[BL-13-00011 Hansen](#)

RE: Hansen Boundary Line Adjustment (BL-13-00011),

Map Number 19-16-18052-0313 Parcel Number 567134
Map Number 19-16-18053-0009 Parcel Number 717134

**BOUNDARY LINE ADJUSTMENT EXHIBIT
KITITAS CO. TAX PARCEL NUMBERS 717134 & 567134**

**BOUNDARY LINE ADJUSTMENT EXHIBIT
KITITAS CO. TAX PARCEL NUMBERS 717134 & 567134**

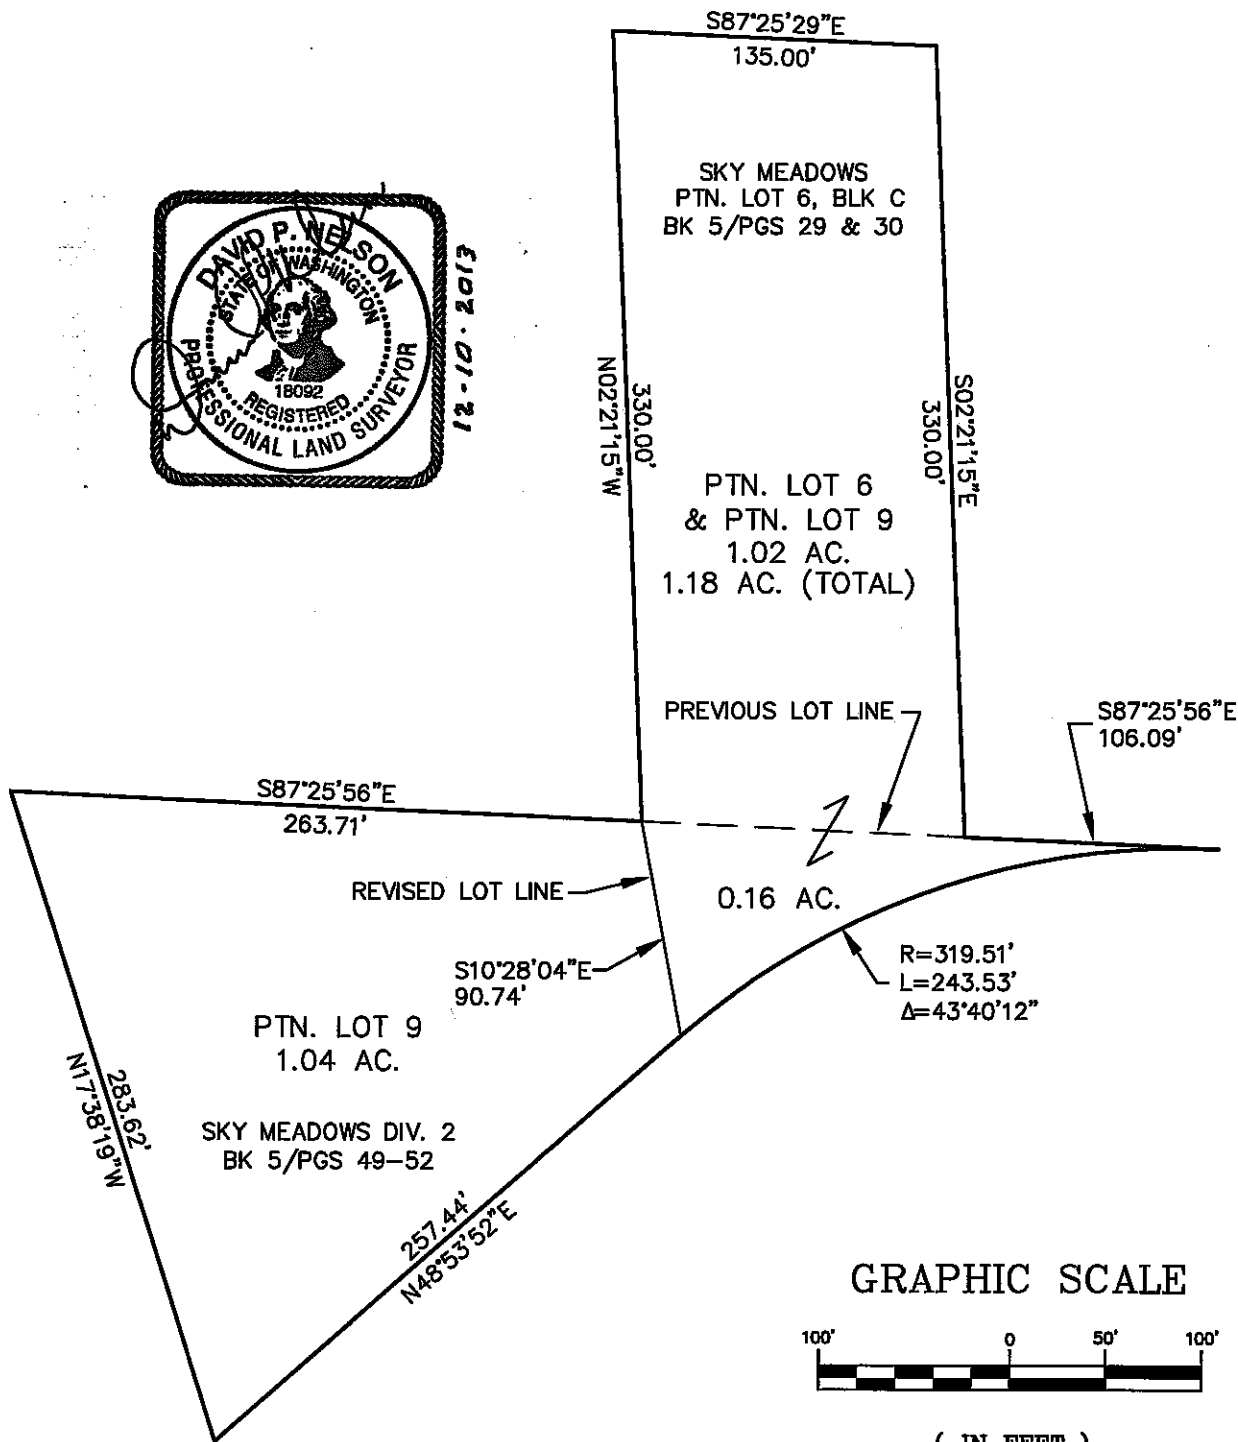
We have some math issues here on recorded acreage and the exhibit submitted... are these numbers corrected by survey... original plat numbers wrong...? See attached page 1, let me know.

The BLA was to eliminate one line on the South side of lot 6 and add a second extension to lot sixes west boundary as depicted in the attachment. It appears that the line needing deletion was done but no line was added to the west of the property creating two separate lots. Rather, it appears that the two lots were combined unless I am missing something in the drawings.

Acreage Clarification:
1.36 - .16 = 1.20: Why is
053-0009 shown in exhibit as 1.04

The problem is with lot 9. The assessed acreage is incorrect. The calculated acreage for lot 9 is 1.20 acres. The original plat did not broadcast acreage of the lots and someone came up with 1.36 acres for lot 9.

I believe a Record of Survey is what Christy needs to have recorded to change the acreage. It is expensive to fix and doesn't benefit anyone as I believe the tax levied is for the parcel not the actual size.
